State of Washington
DEPARTMENT OF FISH AND WILDLIFE
South Central Region • Region 3 • 1701 South 24th Avenue, Yakima, WA 98902-5720
Telephone: (509) 575-2740 • Fax: (509) 575-2474

RE: WDFW Comments on AT&T Teanaway Cell Tower ACU-19-00001

Thank you for the opportunity to comment on the Administrative Conditional Use Permit for a cell tower located on the Teanaway Community Forest (ACU-19-00001), henceforth referred to as “the project”. Washington Department of Fish and Wildlife (WDFW) has reviewed the application and supporting documents. This proposed cell tower is located on the Teanaway Community Forest (TCF), of which WDFW is a co-manager of the forest along with Department of Natural Resources (DNR). The management plan adopted for the TCF sets clear indicators that the forest must be managed as a working forest while conserving values for species habitats along with recreation interests that are consistent with watershed protection.

**SHEET NUMBER**  
**A-2.0**

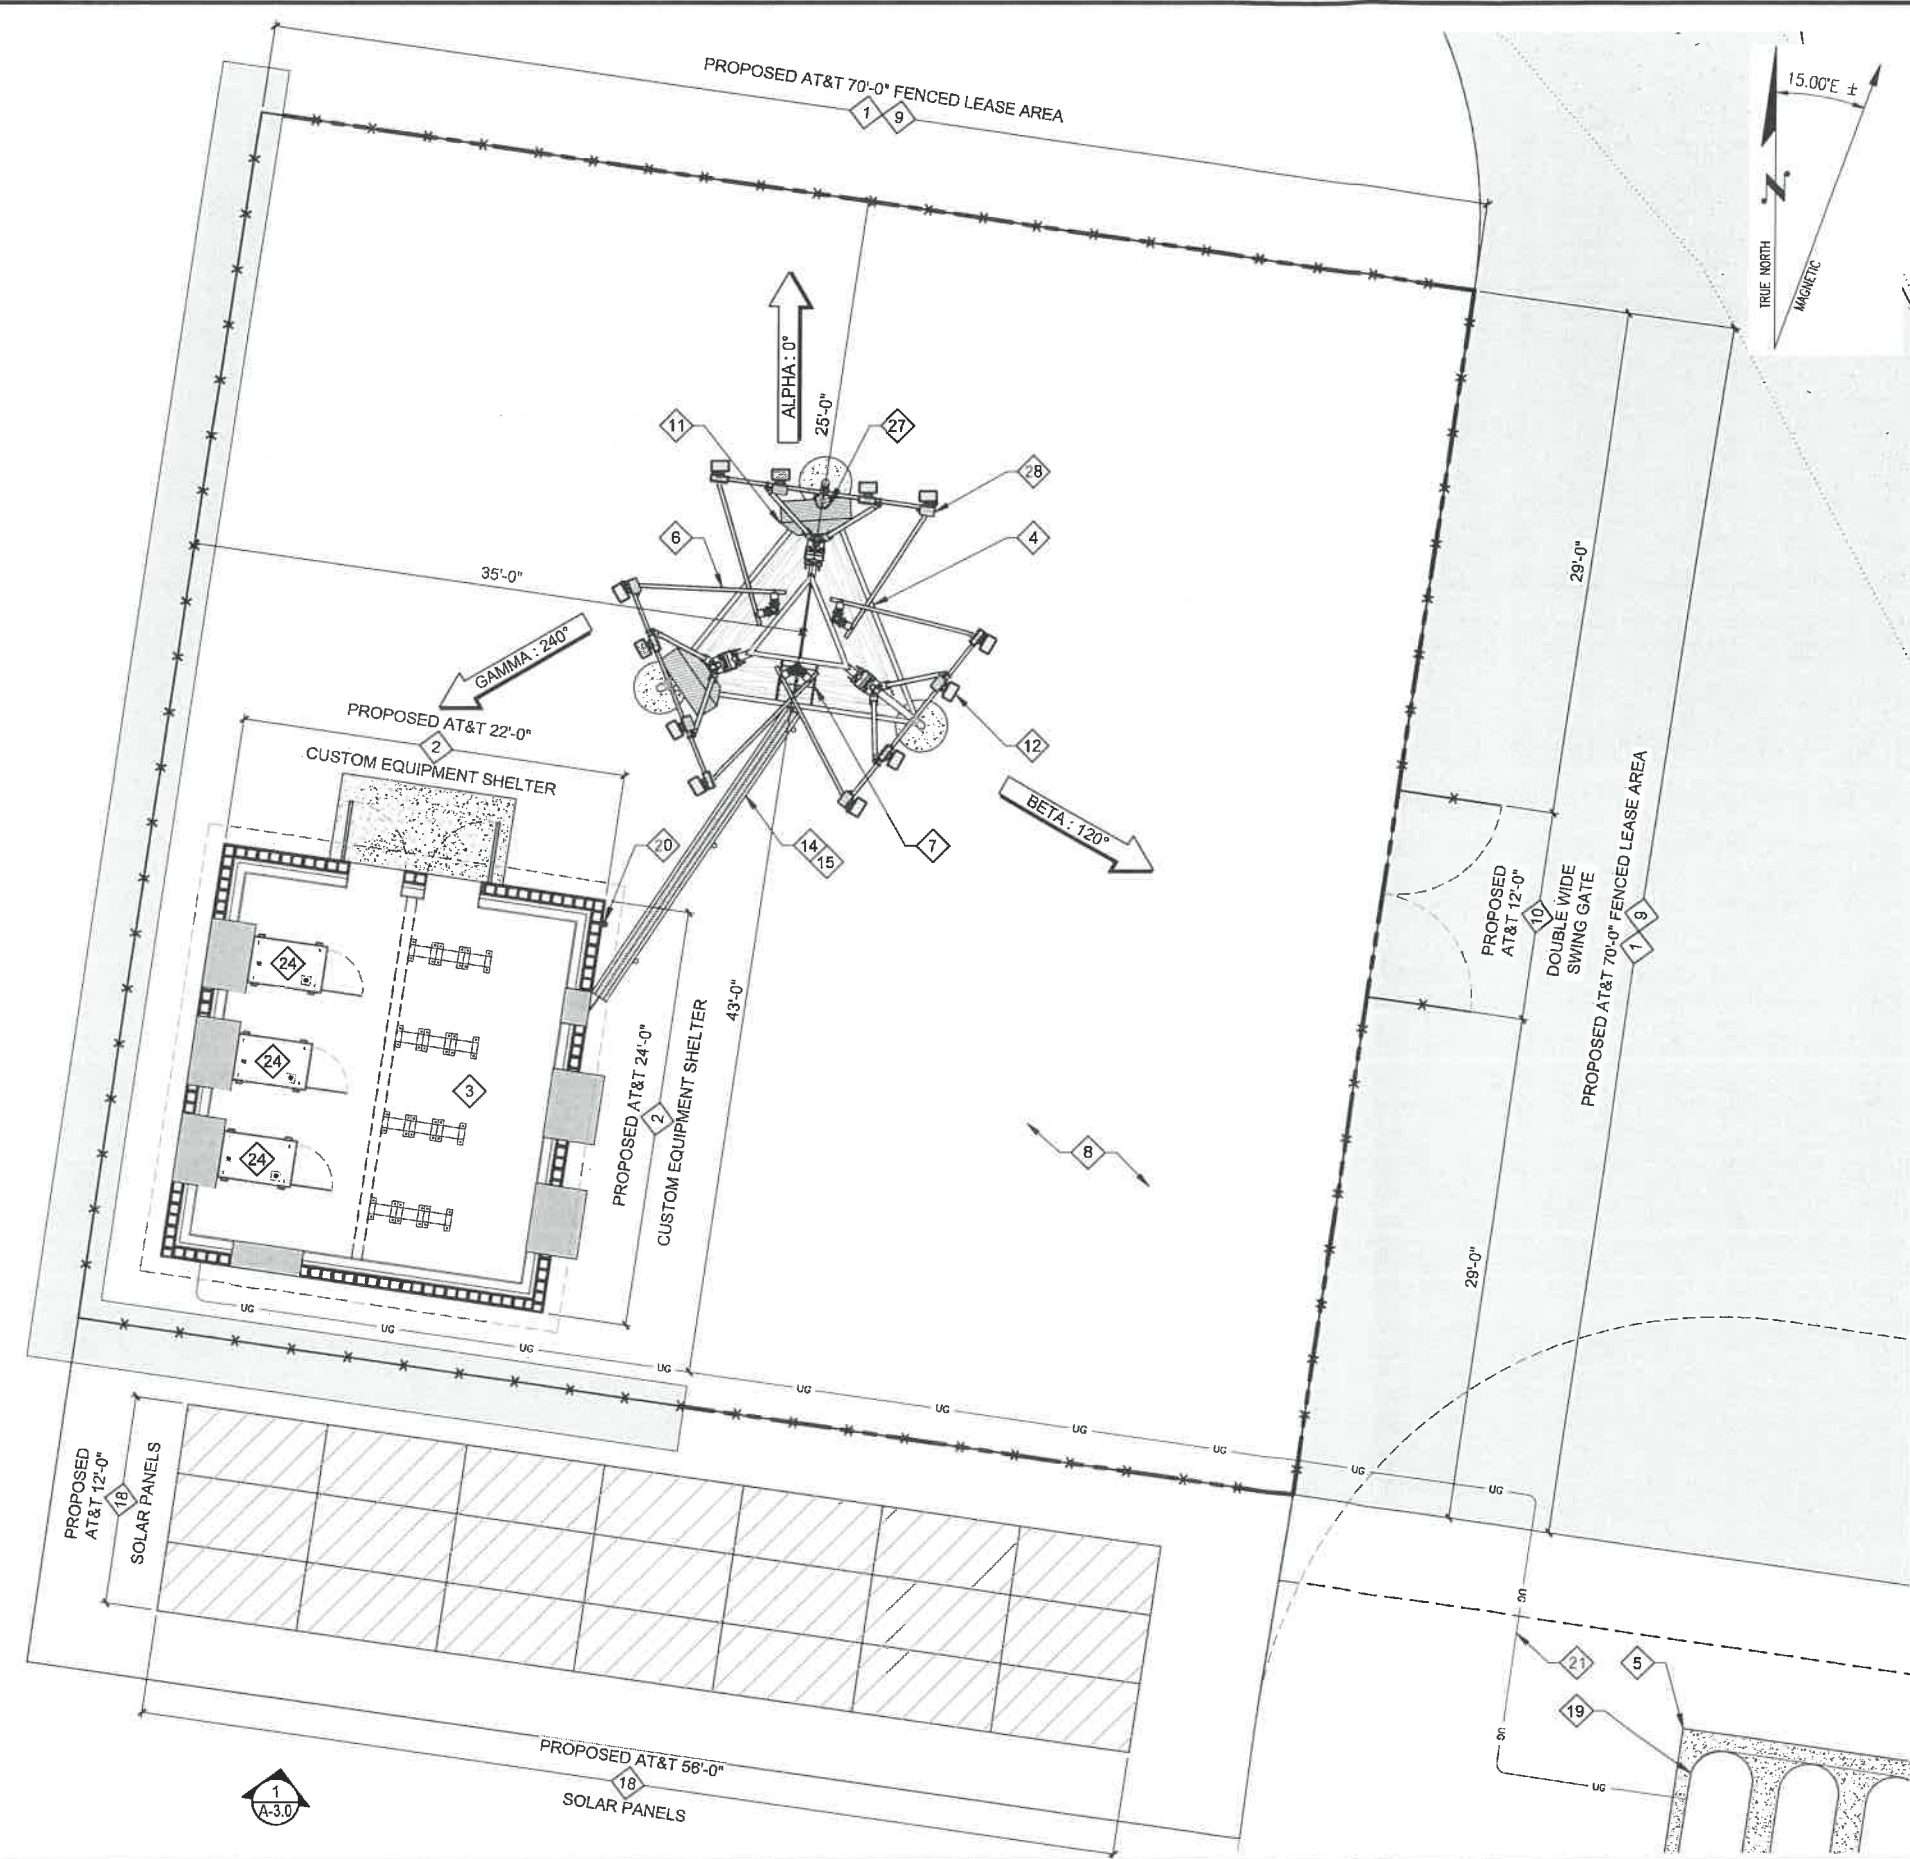
2. The project needs to provide more details on the facilities;
 - a. more details on perimeter security fence installed (it needs to be at least 8 foot in height to exclude deer and elk and of a design that will not harm wildlife, single strand barb wire or no top wire),

- b. explanation of why the solar panel array and the propane tank is outside of the fence-this is public land, so are there concerns over public having access to either the panels or the propane tanks,

- c. clarification on the generator plan, the SEPA checklist states a diesel generator, yet the plans show a propane generator and how do the solar panel array factor into the plan,

3. Weed control; the project is installing a weed block in their fenced area, but no details on how any other disturbed land will be managed for weed control.

**SHEET NUMBER**  
**A-3.0**

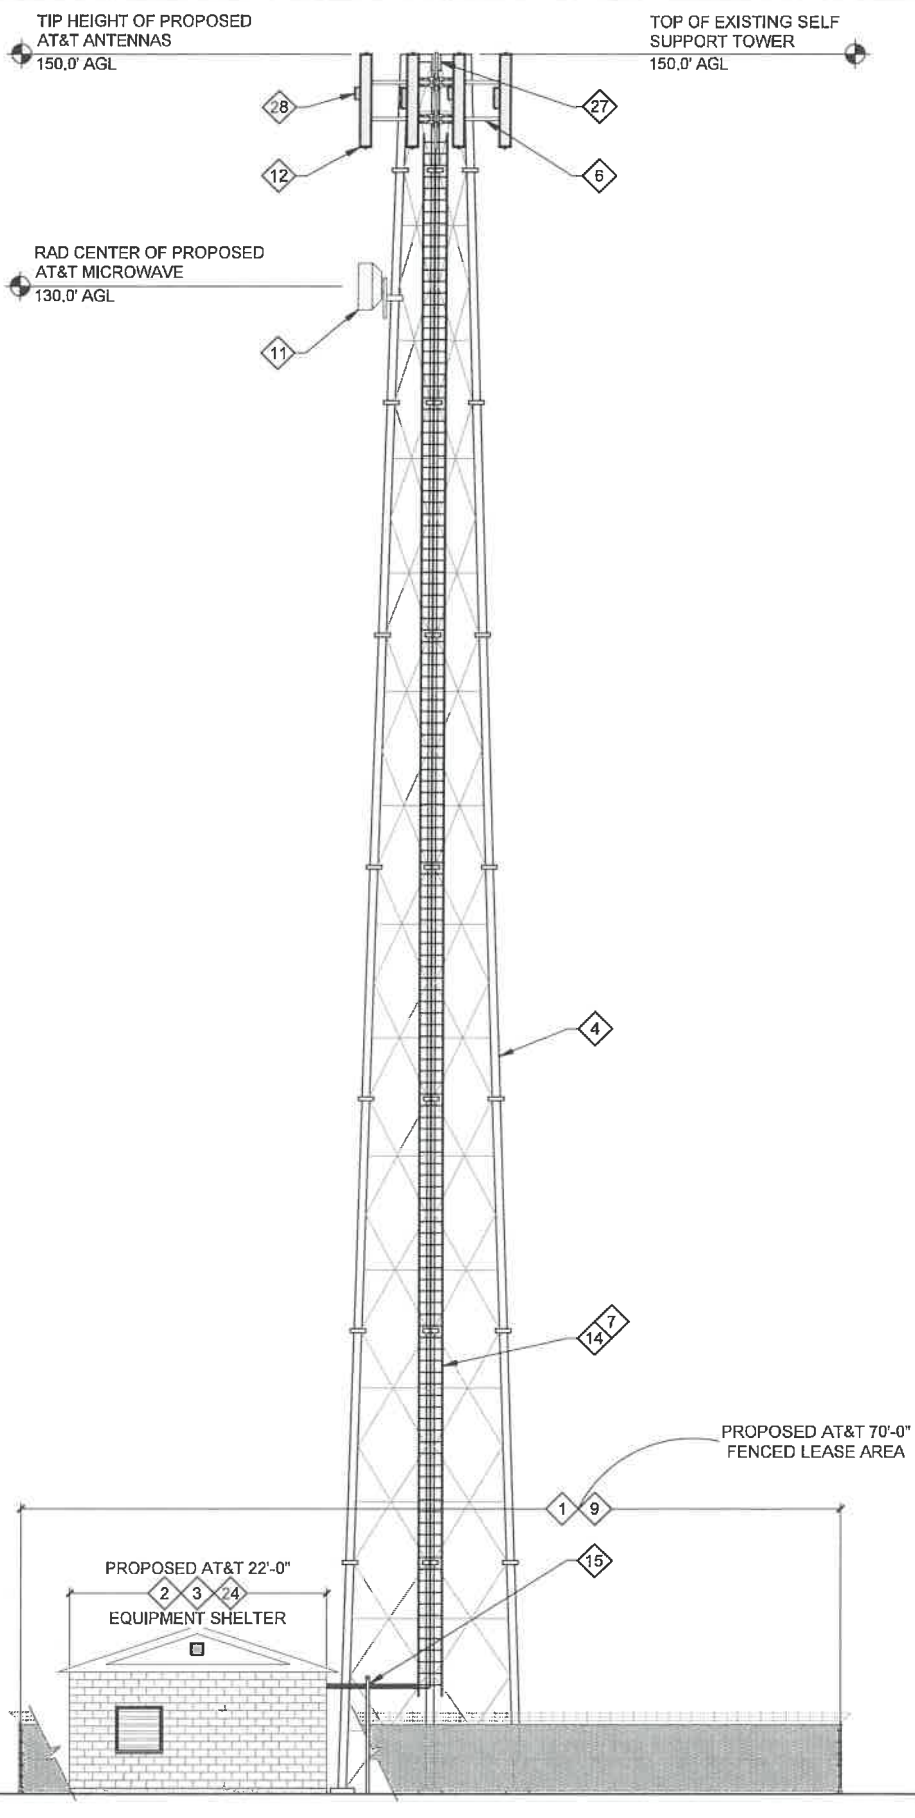
6. Aesthetics, to make the tower more easily blend into the forested landscape, the project should consider replacing the proposed lattice tower with a monopine tower which is more aesthetically in line with the surrounding forest for both habitat and recreational interests.
